Application for Removal or Variation of a Condition following Grant of Planning Permission or Listed Building Consent

Number	<input type="text" value="35"/>
Suffix	<input type="text"/>
Property Name	<input type="text"/>
Address Line 1	<input type="text" value="Campden Road"/>
Address Line 2	<input type="text"/>
Address Line 3	<input type="text" value="Hillingdon"/>
Town/city	<input type="text" value="Ickenham"/>
Postcode	<input type="text" value="UB10 8EU"/>

Erection of single storey side/rear wraparound extension and the conversion of the attached side garage into habitable use, following the demolition of the existing rear conservatory

11687/APP/2025/3185

PROPOSED REAR ELEVATION (1:100)

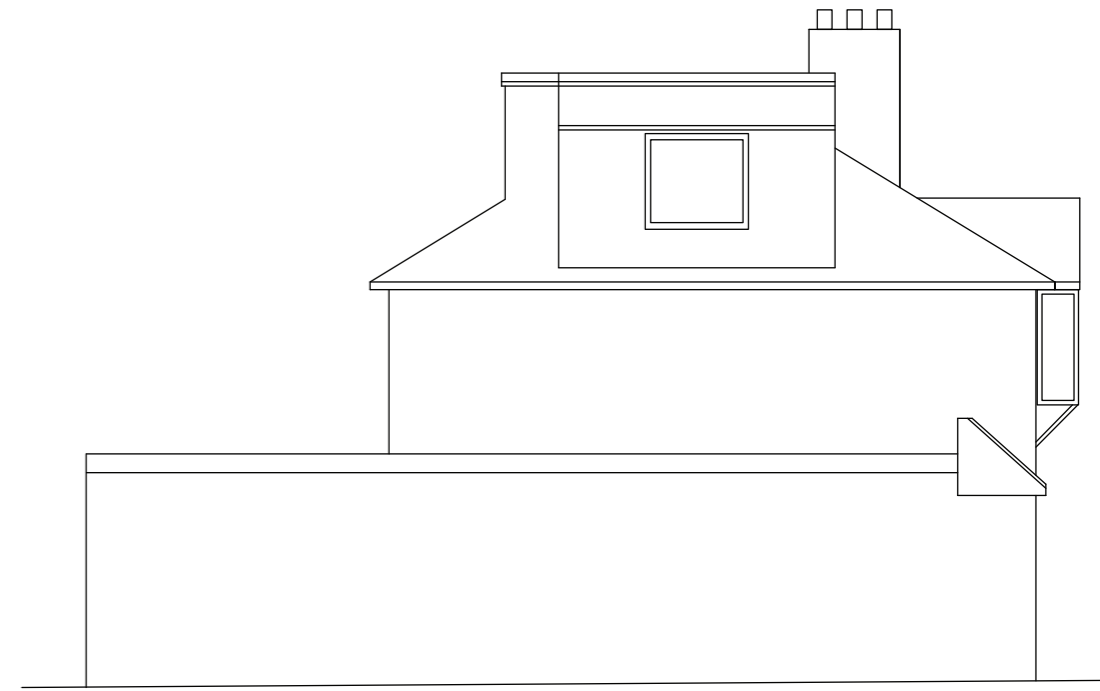
The application seeks to vary Condition 2 (Approved Plans) to allow for a minor amendment to the rear elevation. The proposed change involves replacing the previously approved window/door arrangement with a wider sliding door opening to improve natural light, functionality and connection to the rear garden. The overall scale and footprint of the approved extension remain unchanged.

Condition 2 to be varied to substitute the approved plans with updated drawing set (Revision V7), reflecting amendments to the rear elevation, including the introduction of a wider sliding door opening.
